COCKLE BAY PARK [SSD 7684] - DESIGN INTEGRITY PANEL - SESSION 9

This letter has been prepared on behalf of the Design Integrity Panel (DIP) for the Cockle Bay Park State Significant Development (SSD), in relation to the design integrity process. This letter provides confirmation of the Panel's commentary on the design elements which are supported / unsupported and those elements which require further resolution. The feedback is based on the latest developed design, as presented by Henning Larsen on 14 December 2021.

COCKLE BAY PARK [SSD 7684] - DESIGN INTEGRITY PANEL - SESSION 9

Market Street / Civic Link connection - Landbridge Edge Protection - RTS

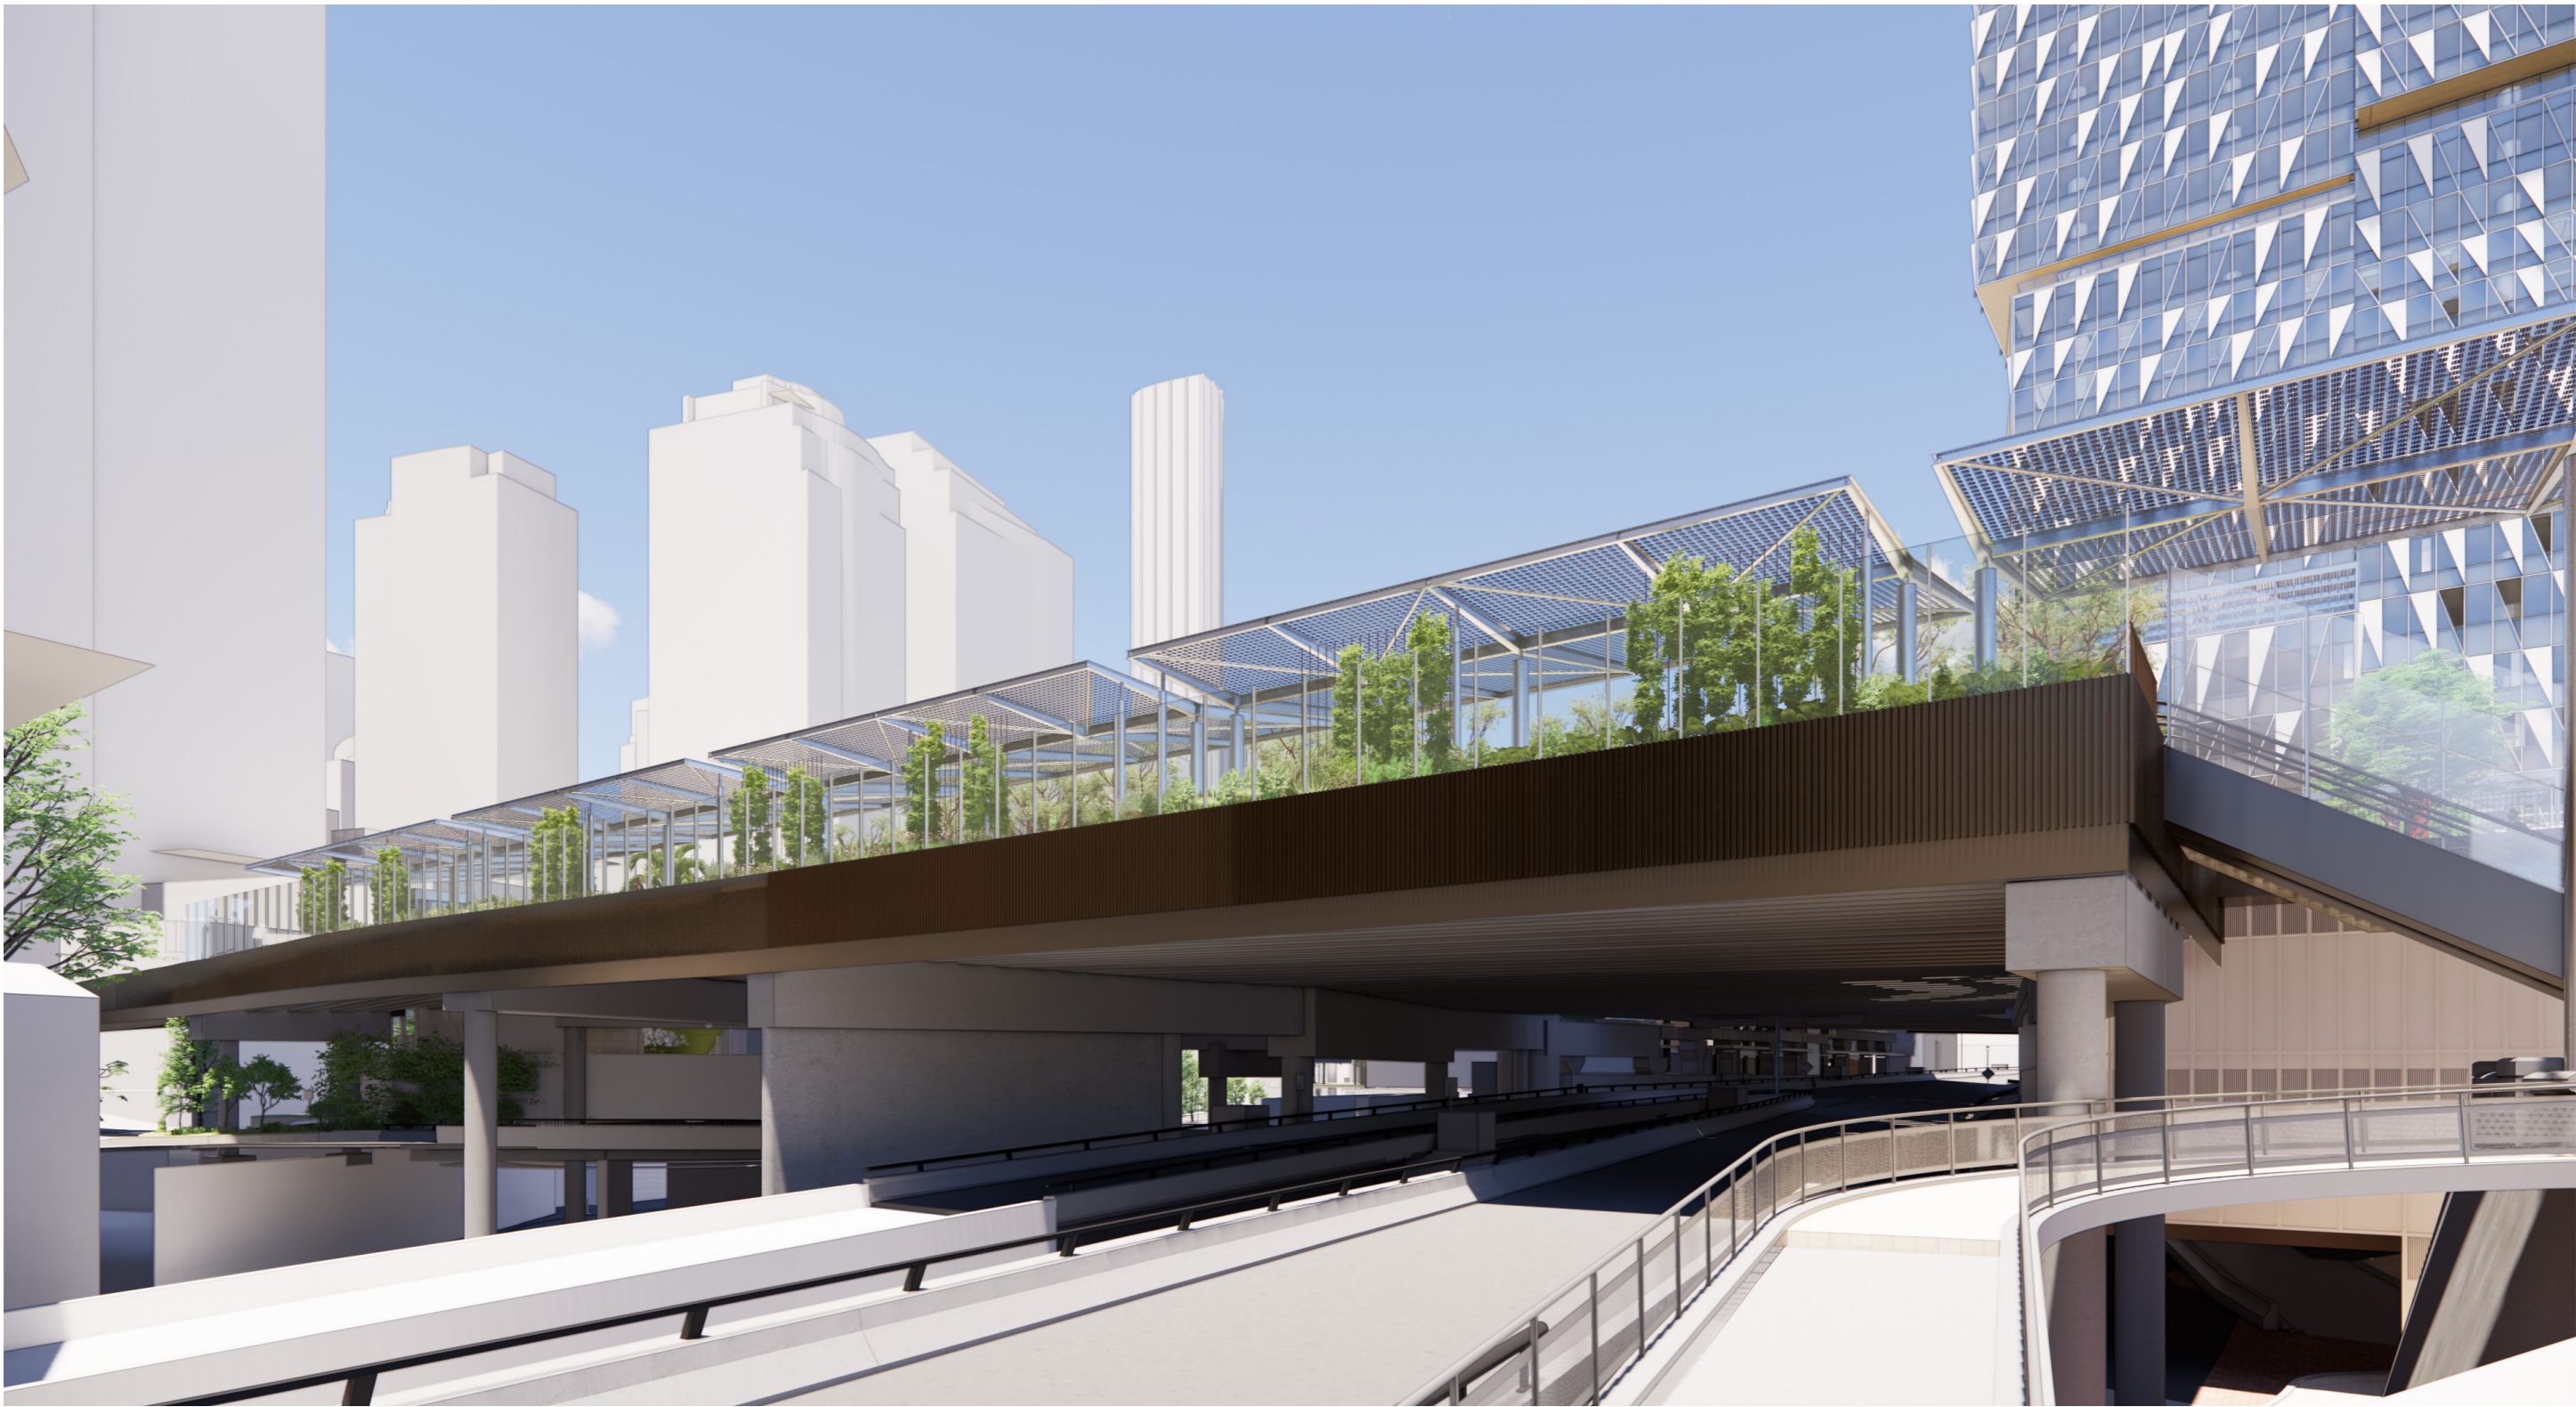
FOCUS AREA	COMMENTARY
3. PUBLIC DOMAIN	
Market Street / Civic Link Connection	<ul style="list-style-type: none"> The Panel continues to raise concern over the Market Street / Civic Link connection, as presented on slides 41 and 42. The Panel was advised that TfNSW requires the northern wall to be of a specific height (3m) for safety and security reasons. The Panel recognises the need for this, however the design submitted to the meeting is for a primarily solid element that would be better as a lightweight structure that visually connects the link with Market St and the northern/central CBD. This would also assist in improving sight lines and way-finding for pedestrians in Market Street heading west towards the site and beyond. The Panel recommends that further design work is required to better engage the civic link with the site context and views along the Market St/Pymont Bridge corridor. As per the DIP Session 8 feedback solutions may include, but are not limited to, replacing solid walls above deck height with a more open/perforated structure or replace the solid elements entirely with a glazed screen system clipped onto deck level that fosters views above and screening of deck substructure below. As discussed at the meeting and further below, the Panel felt that the architectural concept, language and materiality for bridge elements should be clearly differentiated from that proposed for the Wheat Road podium (eastern) facade. The Panel also raises concerns over road directional signage requirements that TfNSW are likely to require, and how this can be successfully integrated into the overall design. Discussions with relevant authorities should be undertaken to determine requirements. In relation to weather protection of the Civic Link escalators, the Panel appreciates that a range of canopy options have been tested, and had the benefit of reviewing this over the course of previous DIP sessions. The canopy cover presented on slide 45 is extensive, and provides good weather protection whilst retaining reasonable visual connectivity from within the Civic Link. The Panels preference is to minimise screening, to optimise wayfinding and heritage impacts on the Bridge. The preferred outcome is for a more open, simpler canopy (as presented on slide 44), however this would need to be tested against ongoing maintenance requirements, pedestrian comfort and other implications if the weather protection around the escalator was to be entirely removed.

FOCUS AREA	COMMENTARY
3. PUBLIC DOMAIN	
Market Street / Civic Link Connection	<ul style="list-style-type: none"> The Panel commends Henning Larson on the design development undertaken following DIP Session 09, with the updated scheme now considered to successfully engage the Civic Link with the site's context and visual connections along the Market St/Pymont Bridge corridor. The Panel finds that the team has now addressed the recommendations provided by the DIP during Session 8 and DIP Session 9, and that the architectural concepts, language and materiality for bridge elements is now appropriately differentiated from the Wheat Road podium (eastern) facade. Following discussions with TfNSW the design team has also advised that directional signage will not be required to be located on any of the bridging spans or elements. Whilst the overall vision and materiality is supported, the Panel recommends that Henning Larsen further consider the relationship between the bridge materials and the exposed headstocks and substructure when viewed from the north. For example, the height of the bronze band/s below the vertical ribs could be marginally increased to fully conceal the entirety of the exposed concrete substructure above the four headstocks (refer below) so that this element presents if possible as a subtle, seamless arc across the visible breadth of the land-bridge (refer slide 18). The visible ends of the land-bridge headstocks warrant further design consideration. These sit within a family, but currently have different shapes and geometries. Given the exposed nature of these engineering elements, it is recommended that a more refined architectural approach be further considered. The Panel notes that the heritage listed Pymont Bridge is outside of the project scope. However, new vertical transportation elements, connections and balustrades are required to be integrated into this fabric. The position of the stairs/escalators relative to the sandstone pylons is an important consideration in the context of this State-listed heritage item. The Panel recommends that the

FOCUS AREA	COMMENTARY
	<p>design team review if this element can be inset into the land-bridge structure as far eastwards as possible.</p> <ul style="list-style-type: none"> In acknowledging the detailed nature of this commentary, the Panel encourages the team to refine the design geometry relationship between the stairs and escalators, as viewed from Pymont Bridge (slide 23). The awkward detail resolution that often arises from the different pitches of the stair and escalator should be carefully resolved to present as one unified, simpler element (Wynyard Walk could be seen as an example of where this has been successfully resolved).
